From: Kingston Parish Council [REDACTED]
Sent: 01 July 2015 13:18
To: Ross Leal
Subject: Re: Russet House, Gorse Avenue, Kingston Gorse, Kingston - K/17/15/HH

From: Ross Leal
Sent: Tuesday, June 30, 2015 9:45 AM
To: Kingston Parish Council [REDACTED]
Subject: Russet House, Gorse Avenue, Kingston Gorse, Kingston - K/17/15/HH

I refer to the above application.

Job Title	
Russet House, Kingston Gorse	
Client	
Miss S Masson	
Drawing Name	
Driveway & Landscaping Plan	
Drawing Status	
Planning	
Drawn by	DF
Date	June 15
Checked by	Date
Drawing Scale	
1:100 at A1	
Drawing No	Status Revision
15753/ 07

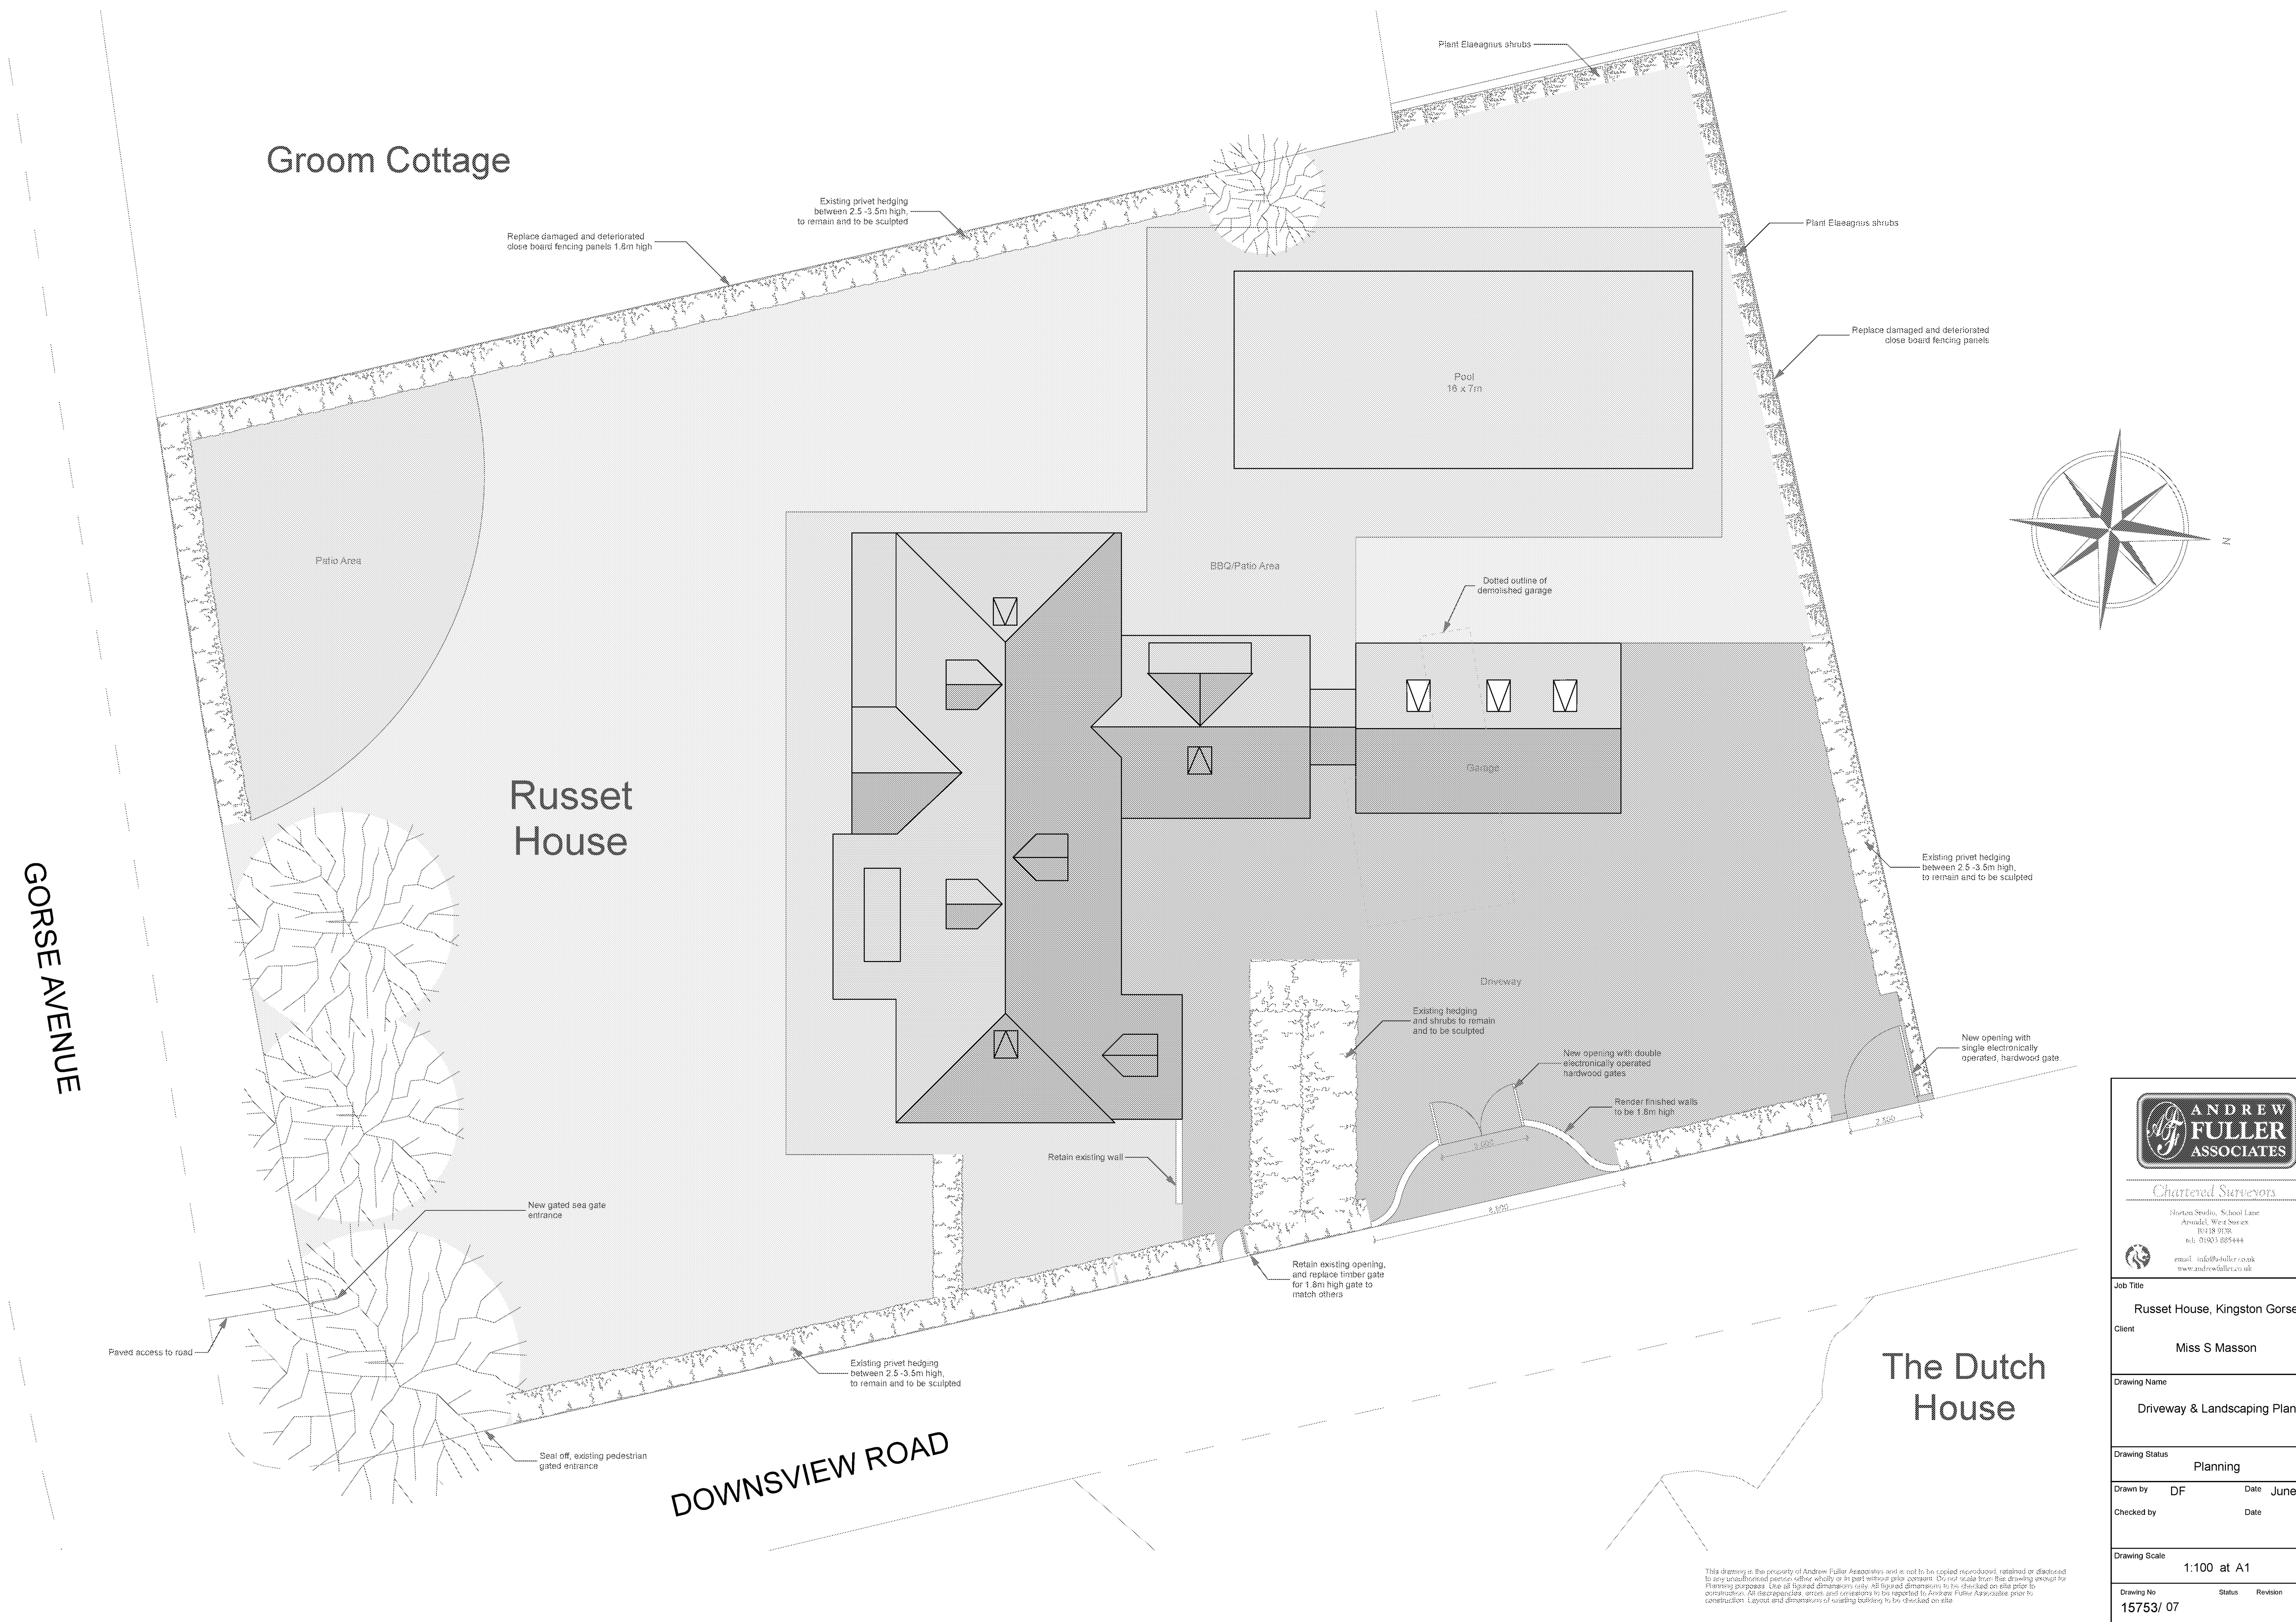
Council considers that our objections have been met by the two conditions you propose:

1. Retain existing hedging
2. Privacy screening to balcony.

I have attached a copy of your Council's response to this application, together with a response from the agent/architect which followed. You will see the suggested privacy screening is acceptable and that therefore the PCs concern in this respect has been met. The privacy screening can be secured by condition. Existing hedging is to

be retained, as you will see from the attached drawing which was sent to clarify matters. We can also condition hedge retention if PP is granted.
